From: Martyn White
Sent: 21 January 2019 17:49
To: Planning.Responses
Cc: Richard Castro-Parker
Subject: BR/294/18/PL

BR/294/18/PL

Part one is for a change of use, and associated development to create a multi faith centre for prayer & reflection. Part 2 relates to the addition of a steel gateway through an existing modern repair on a stretch of wall, along with works of repair to the significant Bognor Rock either side of this.

DRAWING Proposed floor plans
1:75 @ A3

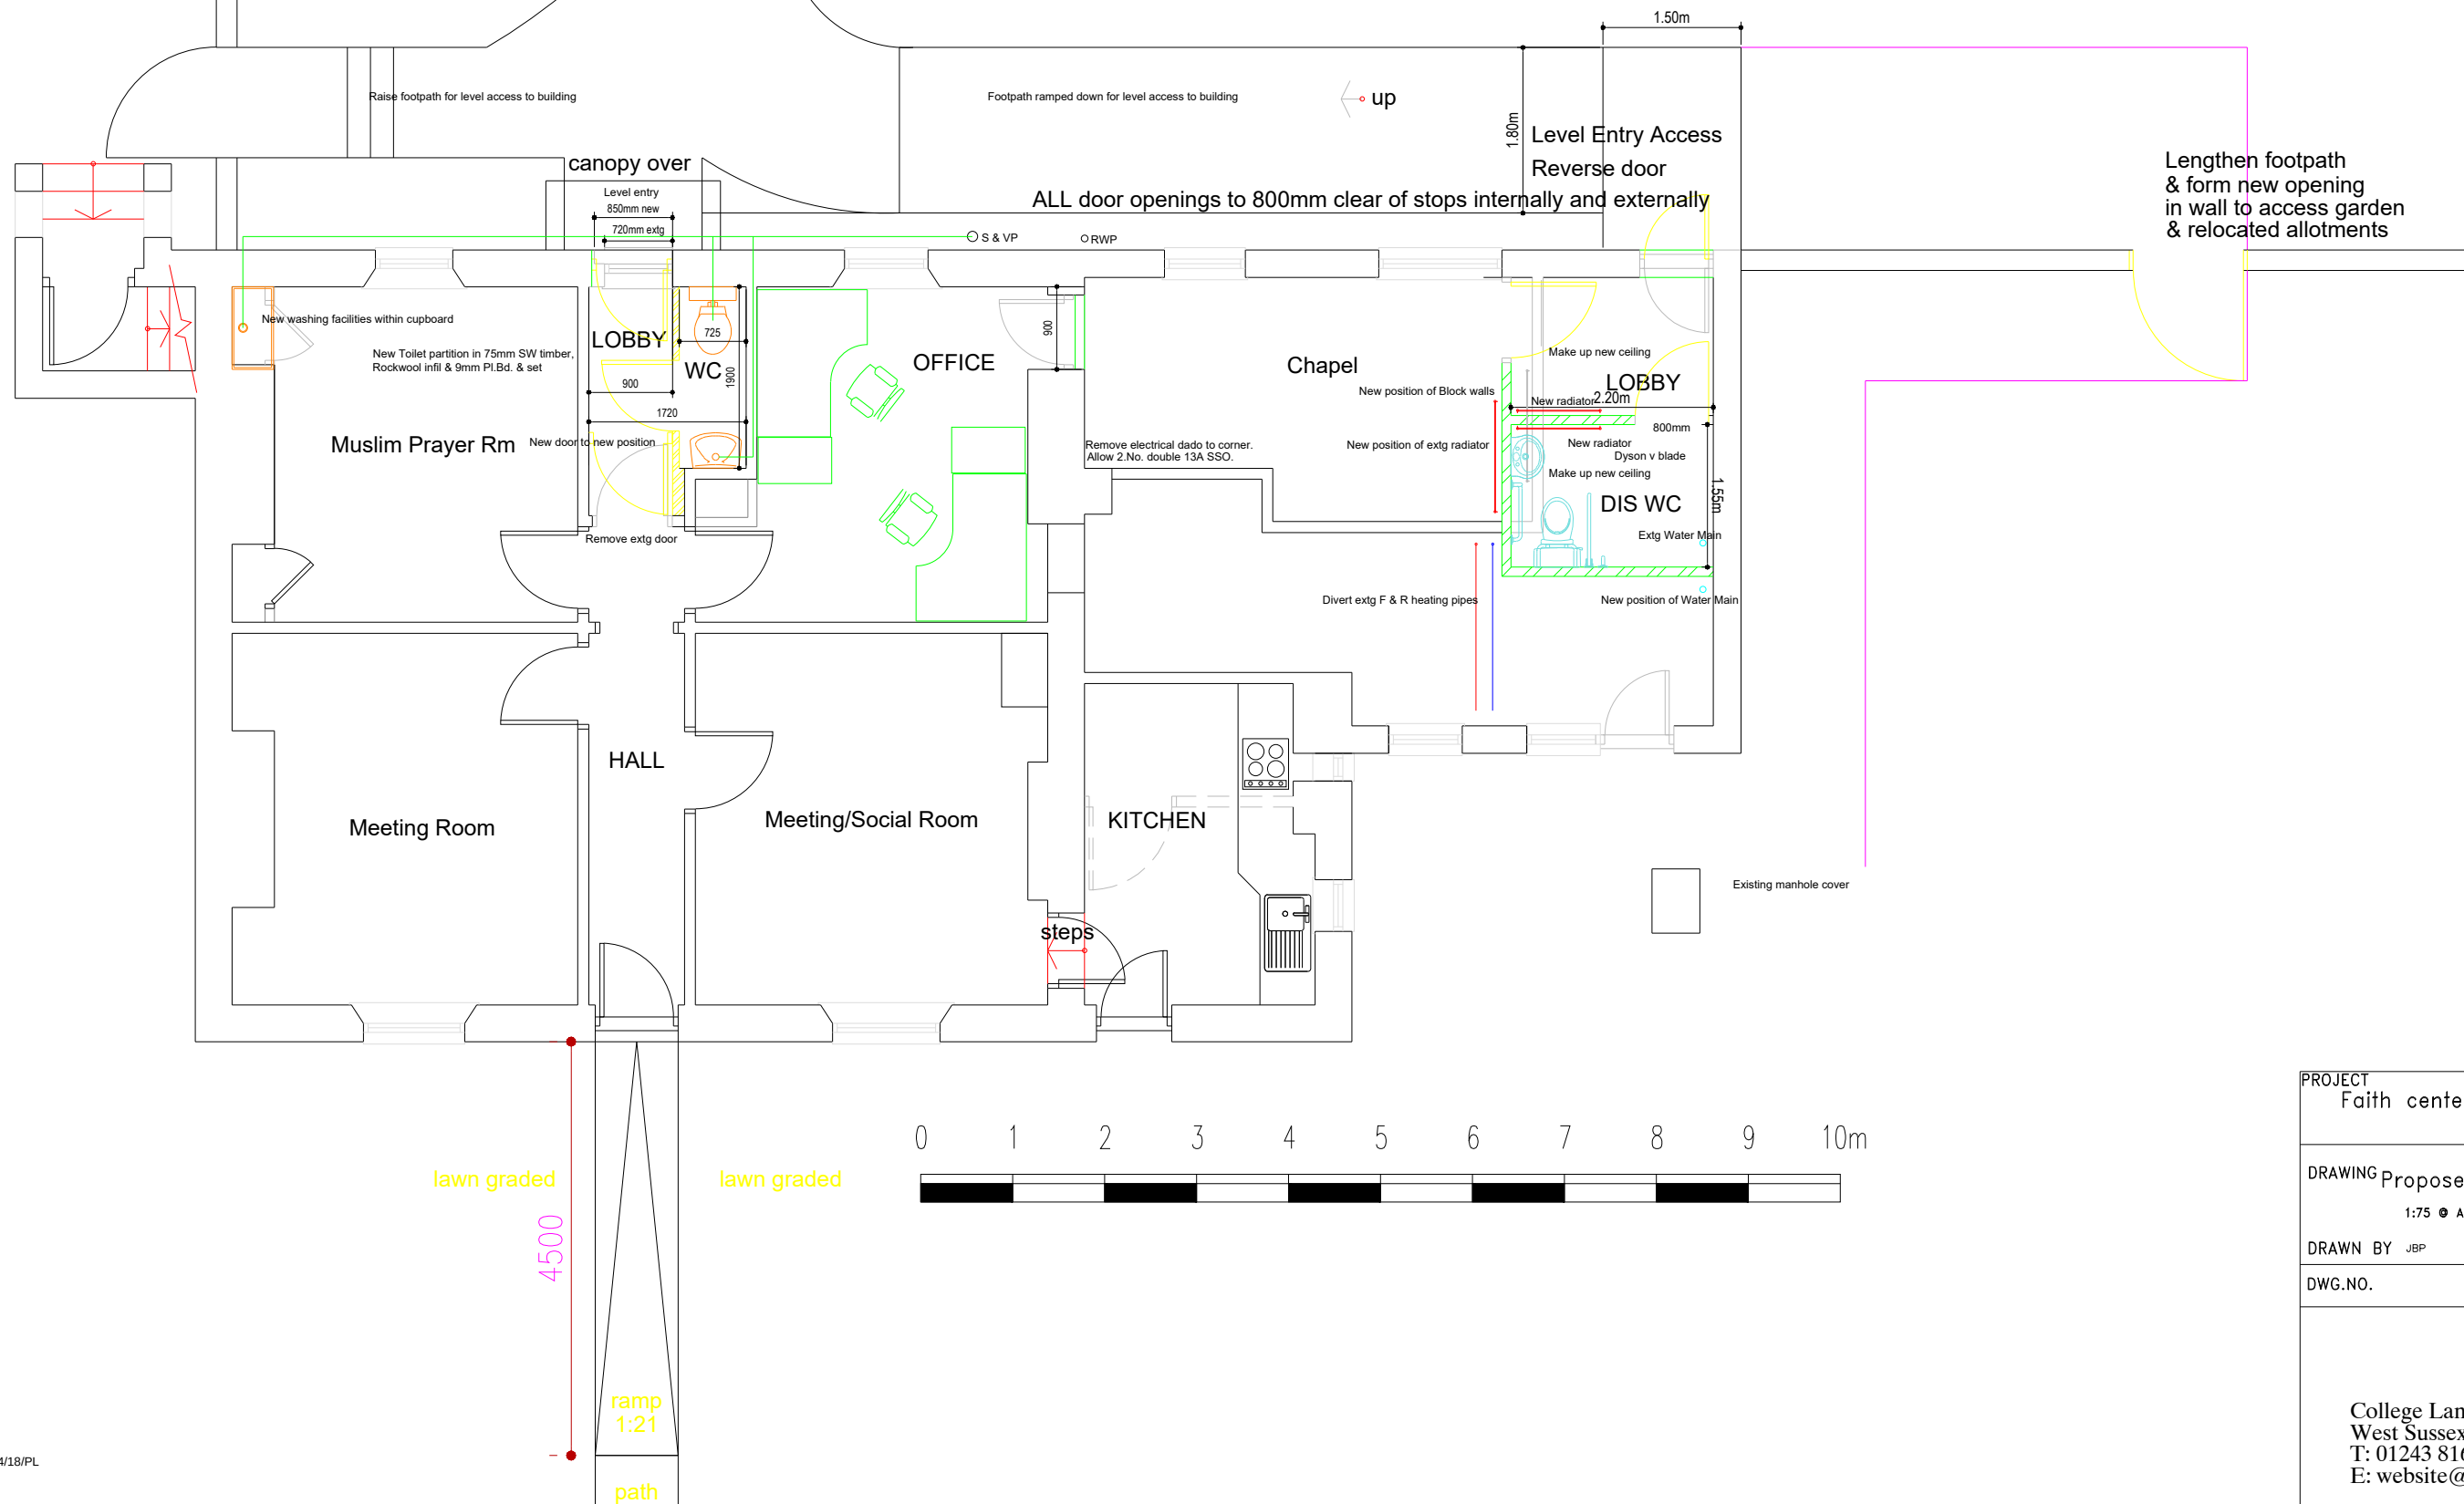
The change of use is considered to be acceptable, as it will allow the building to remain in constant use. Minor works are proposed to the interior of the building to create two cloakrooms. Such alterations are small in scale, and will not harm the significance of the building.

Of note is the replacement of a window with a door. It is suggested that the opening had in fact been larger to accommodate a door. As a consequence, the proposal is acceptable, subject to the design of the door.

It is requested that a door design is prepared which reflects the shape of the opening, as opposed to using a standard door if possible. Details of the door should be provided for by way of condition.
